From: Graham Evans
Sent: 24 October 2013 09:50
To: Planning.Responses
Subject: FW: Planning Consultation on: R/225/13/

I refer to my comments in respect of previous applications and to previous issue (3) of the "Plant Noise Assessment" dated 29th July 2013.

APPLICATION NO:	R/225/13/
Registered:	18th October 2013
Site Address:	Sainsburys Supermarkets Ltd, Unit C New Road Rustington Littlehampton BN16 3RT
Grid Reference:	506160 103085
Description of Works:	Installation of transformer, generator, substation, sprinkler tank and pump house at ground floor level along with rooftop condenser units.

DRAWING
Proposed Roof Plant

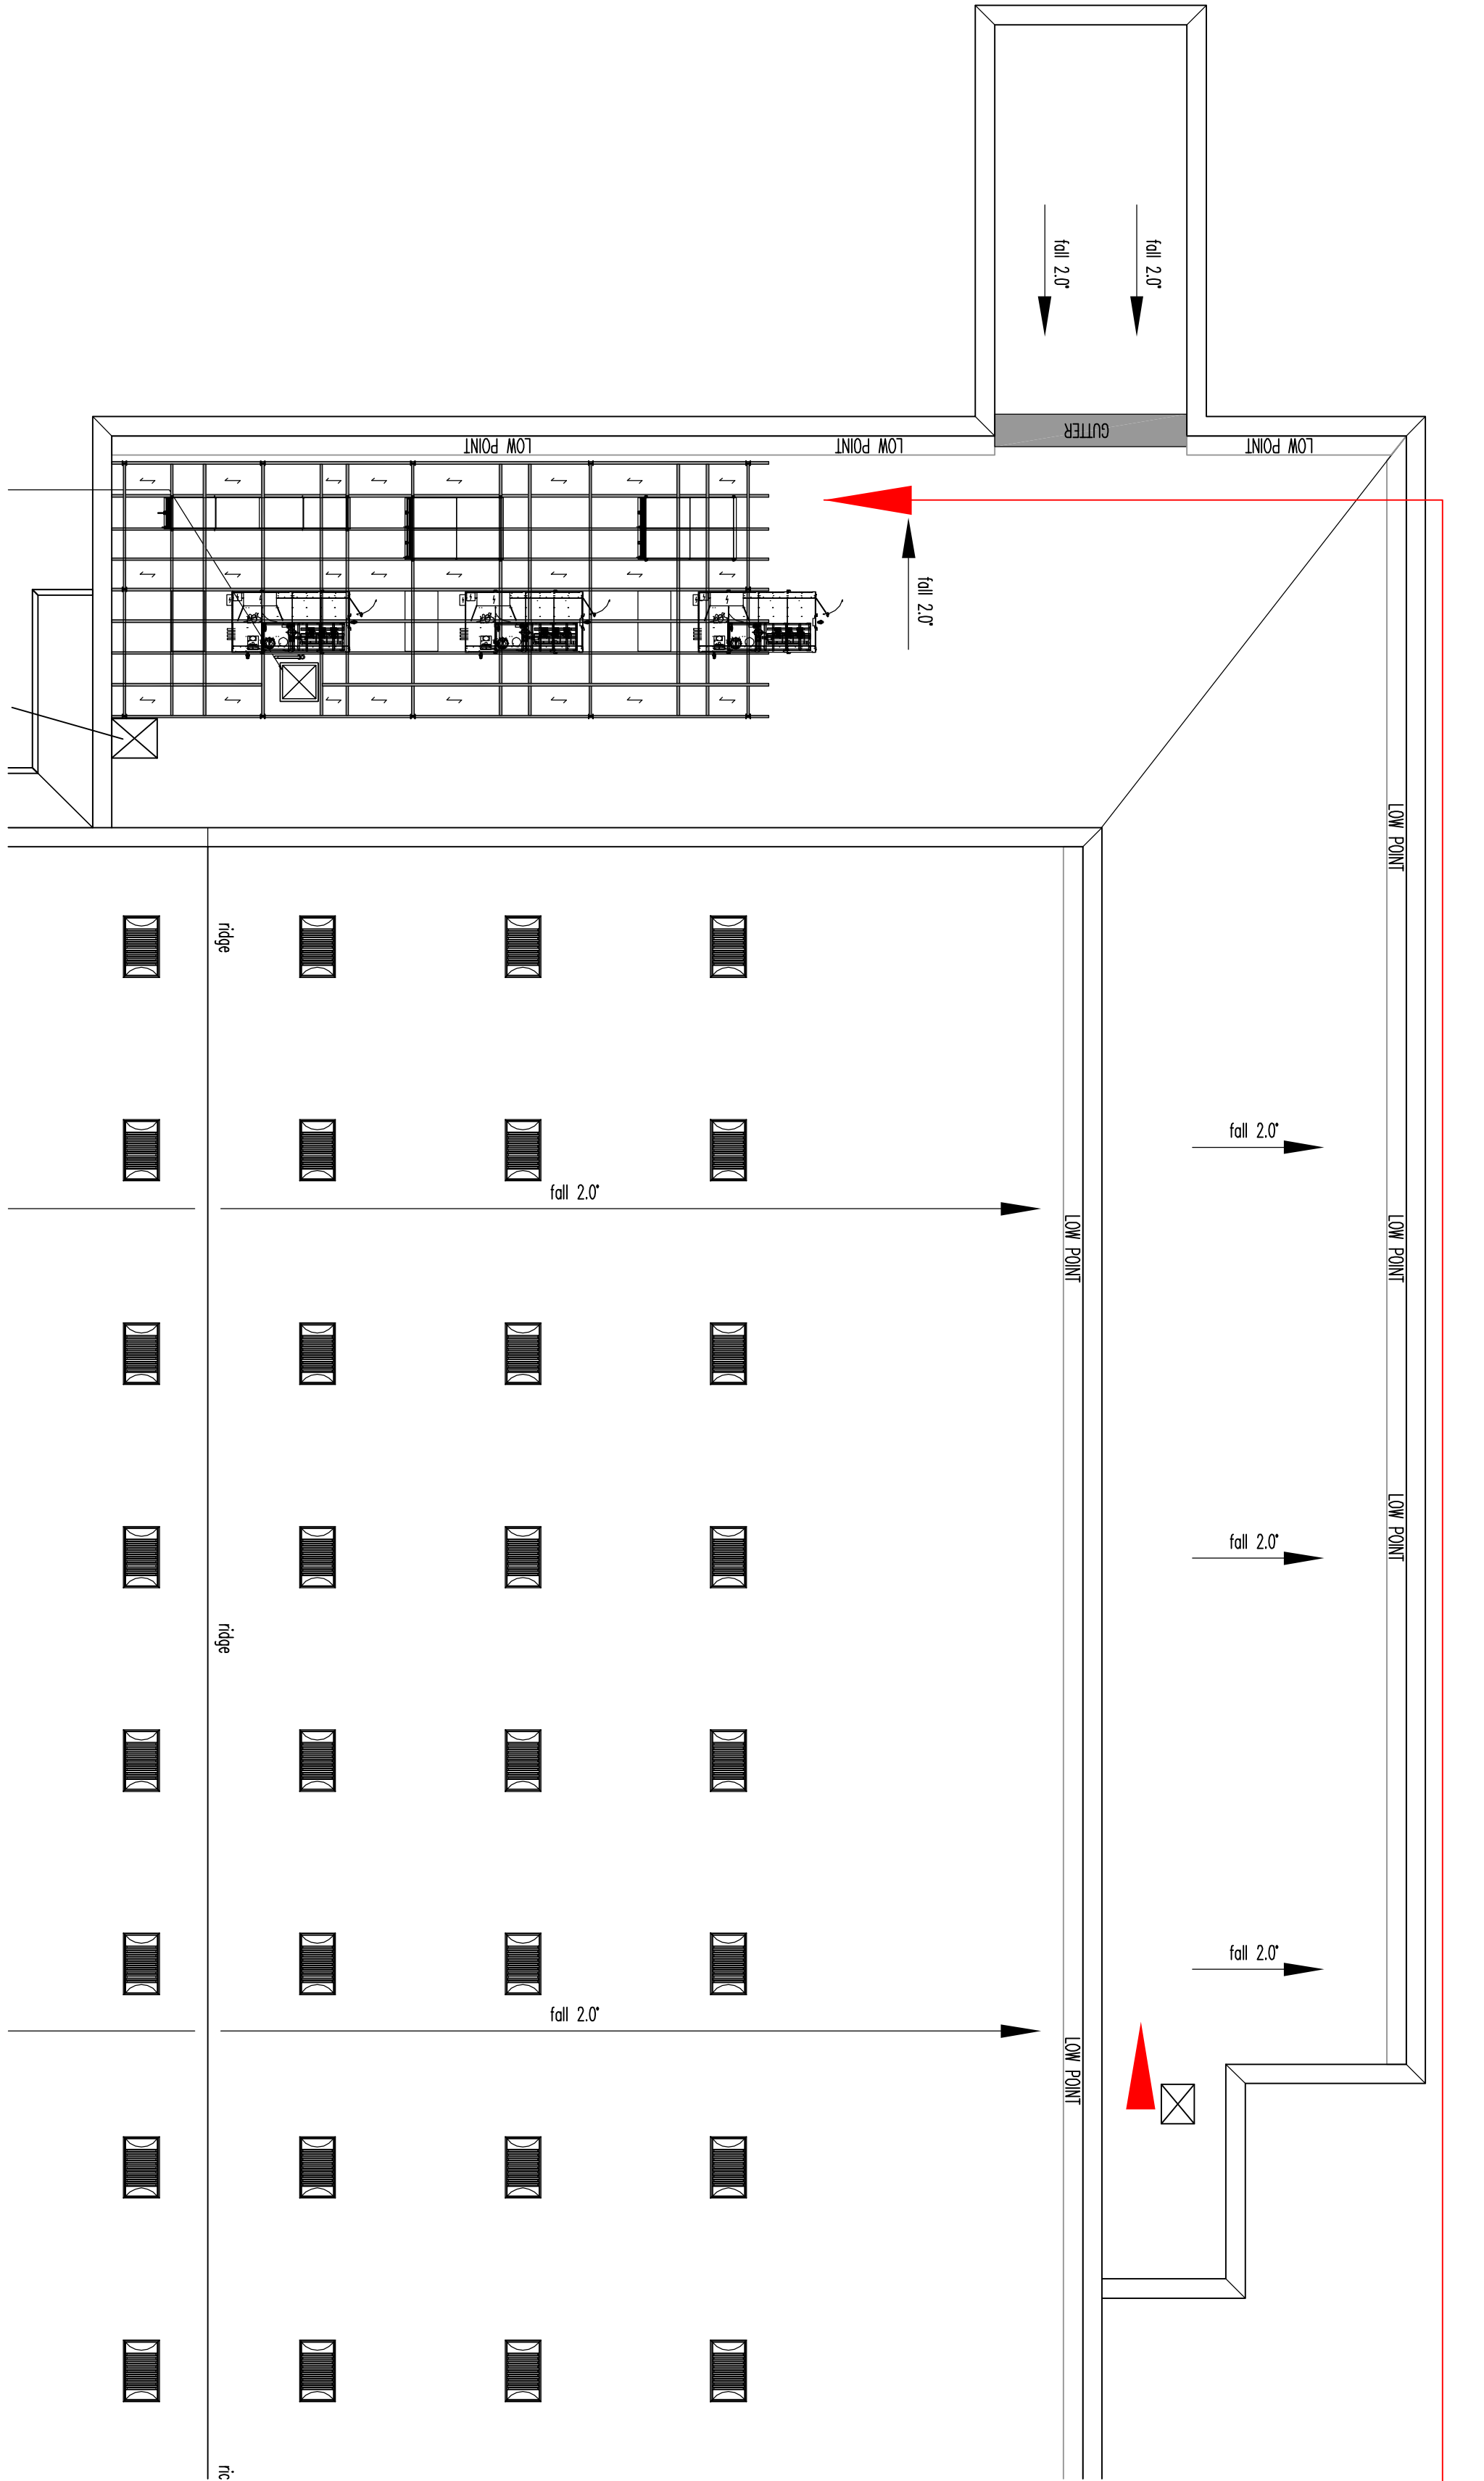
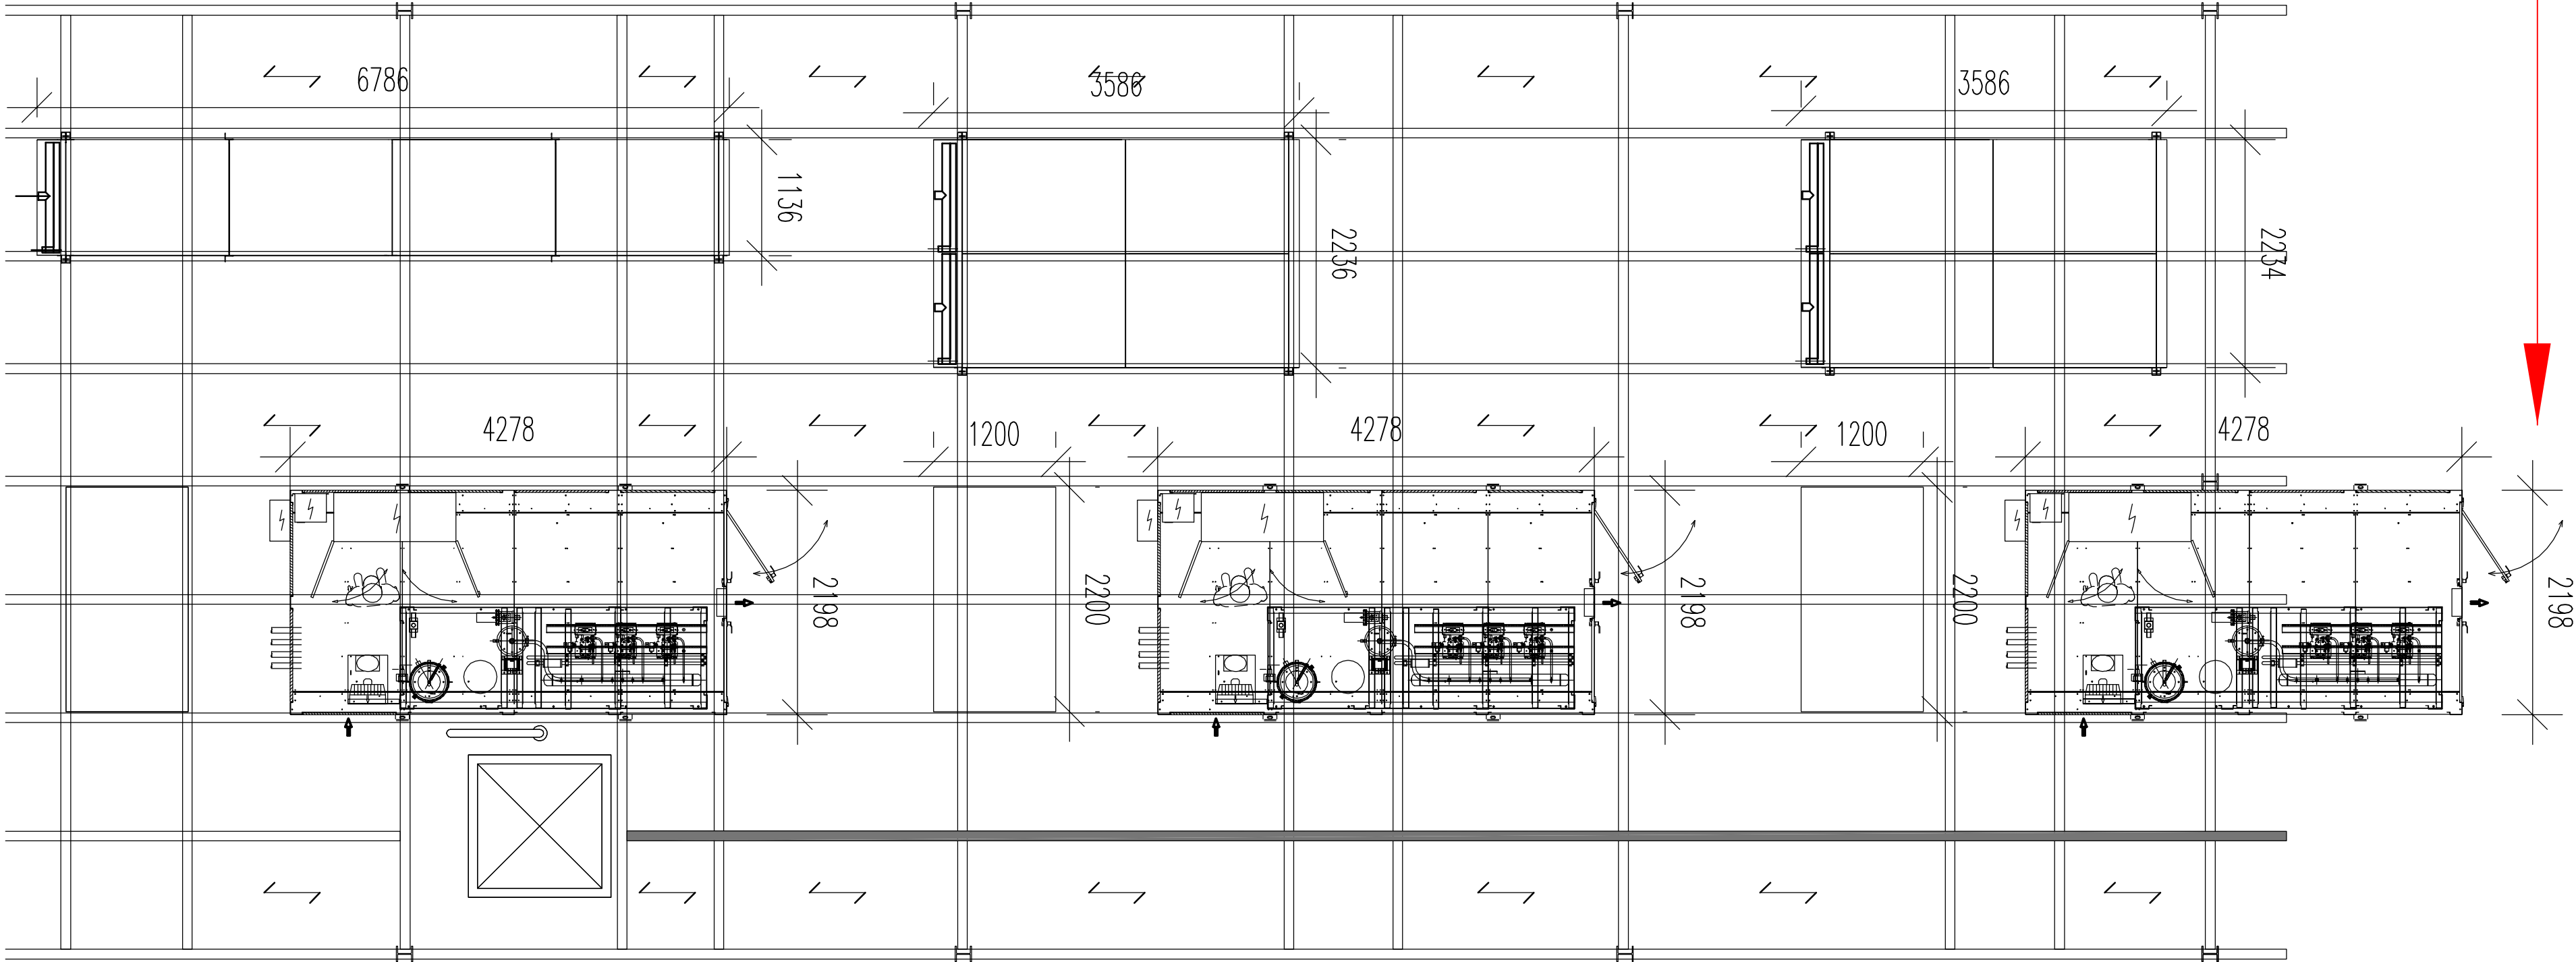
Chapter 5 of issue 3 is an assessment of the key (noise) effects of roof top plant with the plant area enclosed with a 3.2m barrier, predicted noise levels at residential receptors are contained in Table 5.1. A similar assessment is made in Chapter 5 (& Table 5.1) of issue 4, for a revised plant layout both at ground floor and roof level. A comparison of the two tables indicates the impact of noise from the revised plant layout to be significantly worse than the impact of noise from roof top plant enclosed by a barrier. The difference appears particularly significant at night, and it is notable at receptor location R8, Dinsdale Field North, where the predicted night time noise rating may render plant noise audible within residential premises necessitating further works to mitigate the effects.
